PORTLAND MAINE

October 14, 2004

RE: Capricorn Products Change of Use, 1 Rice Street
ID #2004-0040, CBL #354-A-003

UNSHED TOE
CONCRETE AREA OF
CONCRETE
WALL CENTER

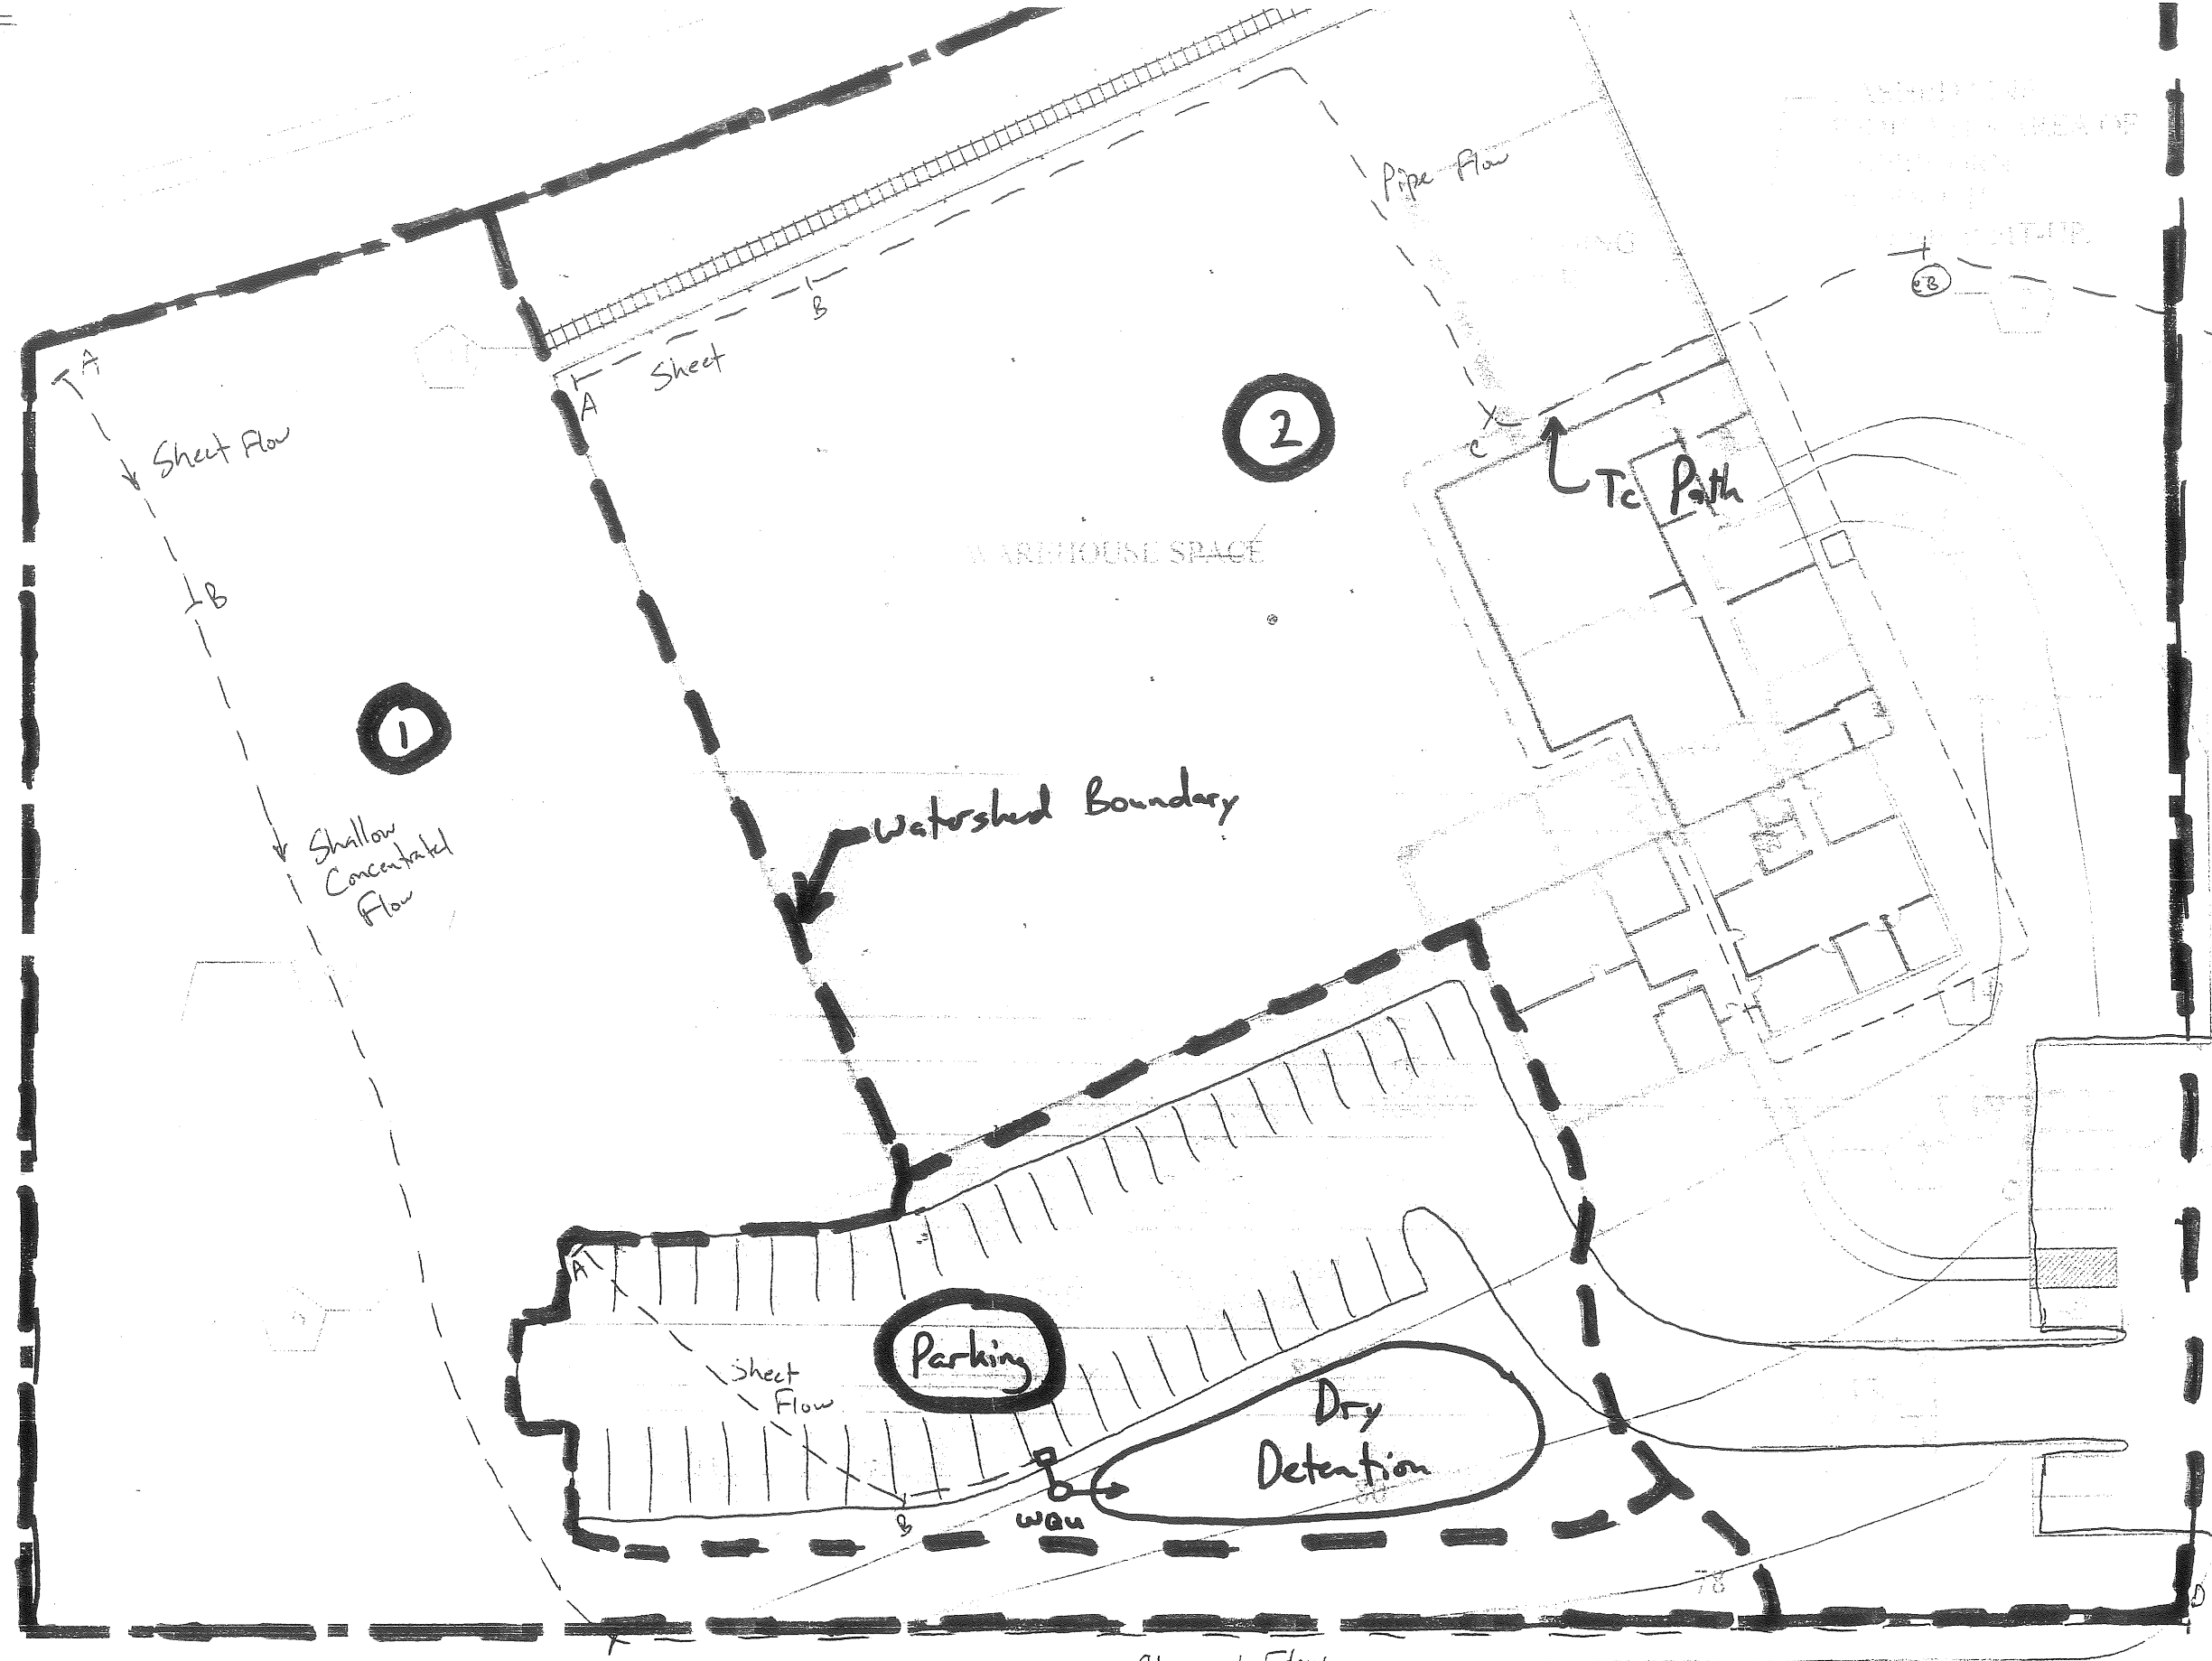
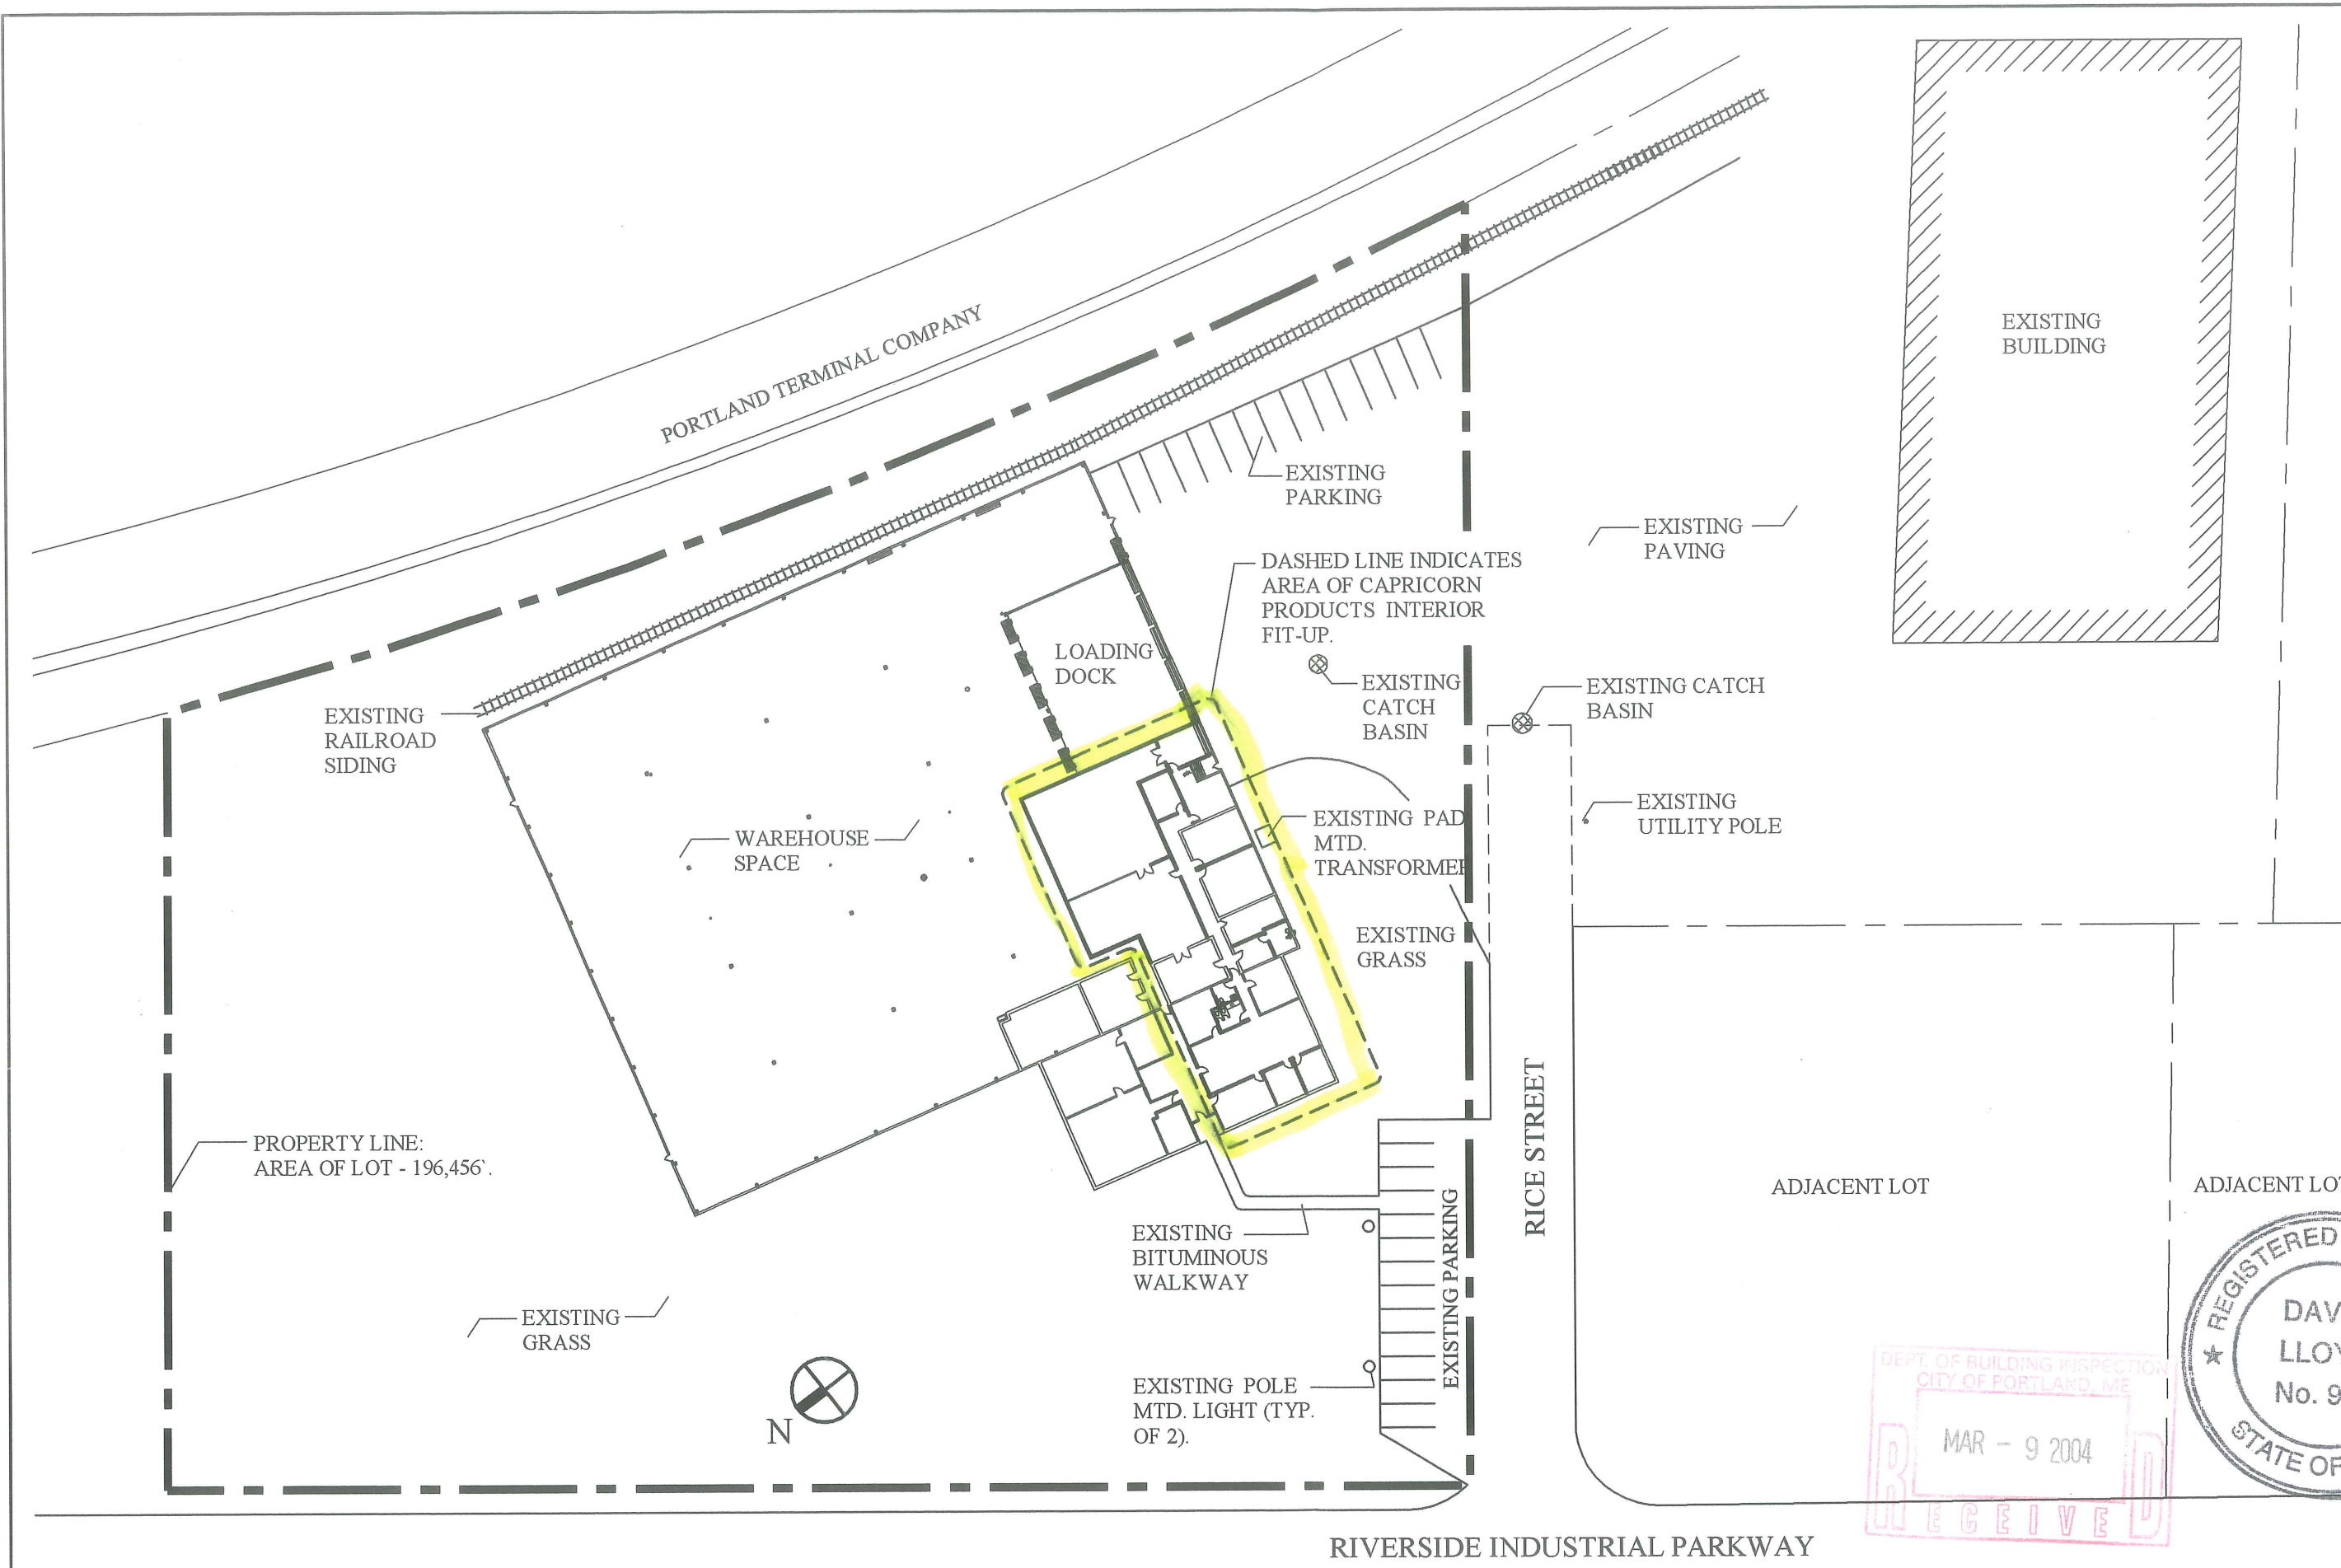
After a recent site visit, it has come to our attention that the development of the site is not in compliance with the approved site plan.

As part of the site plan approval, you were required to provide 63 parking spaces on site. The approved site plan showed 15 existing parking spaces and an additional 50 parking spaces were to be constructed, for a total of 65 parking spaces. However, the 15 parking spaces shown as existing, are not striped and are being used for outdoor storage and only 42 additional parking spaces were constructed.

To bring your development into compliance, you must stripe the 15 parking spaces on the westerly edge of the pavement near the loading docks and you must construct an additional 6 parking spaces to meet the 63 parking spaces required by zoning.
